OBSERVATION/SUBMISSION TO PLANNING APPLICATION

Case Reference: 323761

Re: Observation/Submission to proposed wind energy development at Cooloo Wind Farm

Applicant: Neoen Renewables Ireland Limited

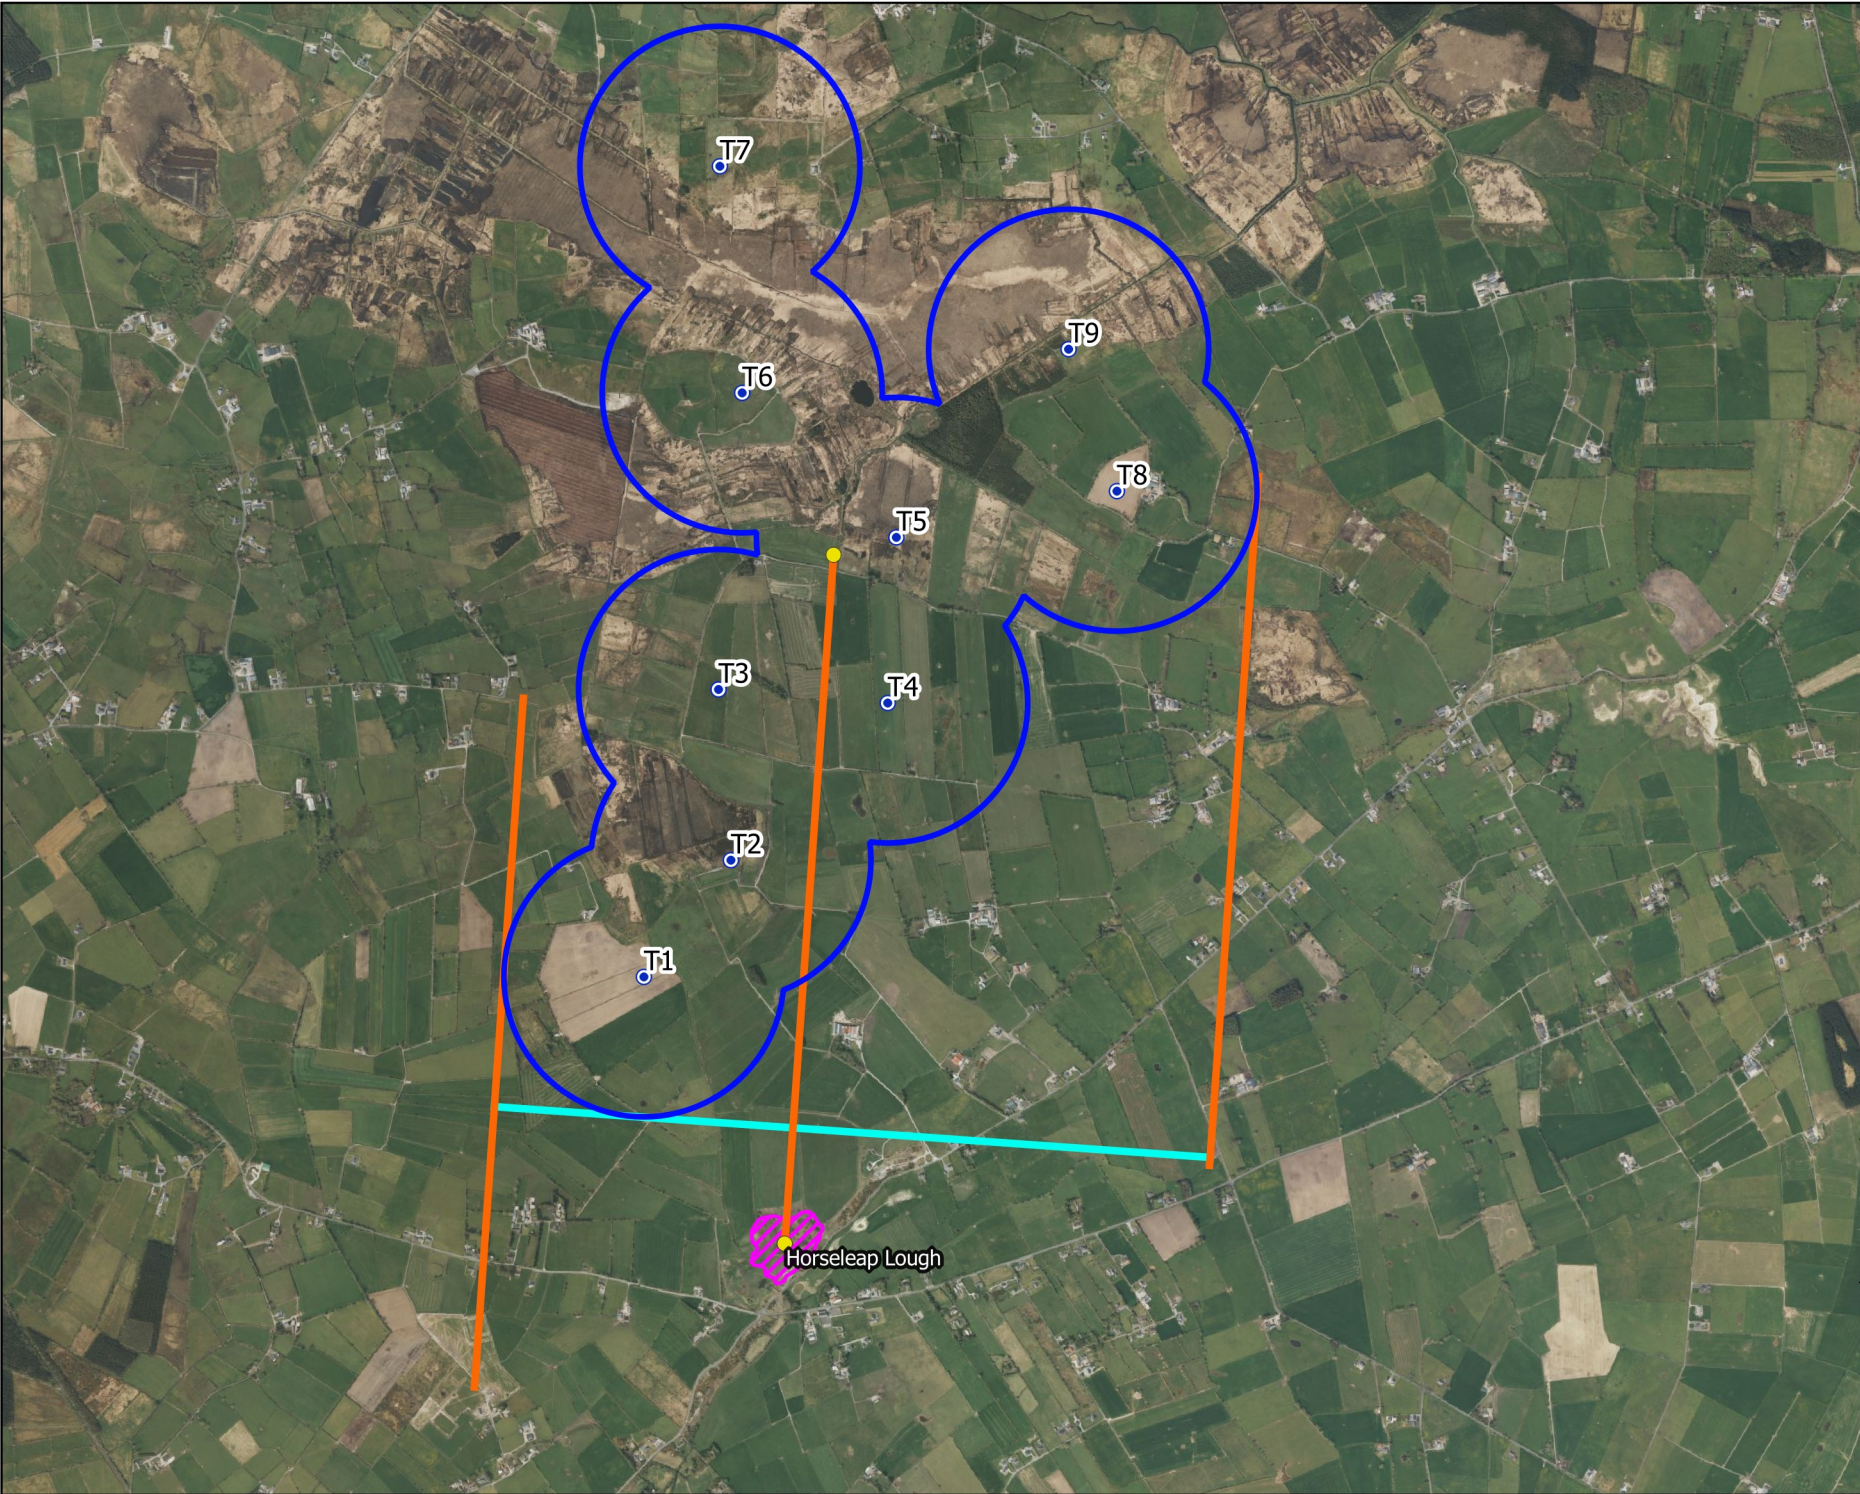
The use of a 99.5% avoidance rate for Whooper Swans, without local validation, significantly underestimates the risk of collision. Evidence from Irish Wetlands Bird Survey (I-WeBS) and BirdWatch Ireland indicates that Whooper Swans routinely commute between Horseleap Lough and surrounding feeding areas at low altitudes that overlap turbine rotor heights. The conclusion of 'negligible risk' is therefore unsupported and unreliable.

Mitigation measures are undefined and untested. Key figures such as flightline maps (e.g., Figure 7-6-1) are omitted, hindering independent review and transparency. Without clear, evidence-based mitigation strategies, there is no guarantee that collision risks can be managed effectively.
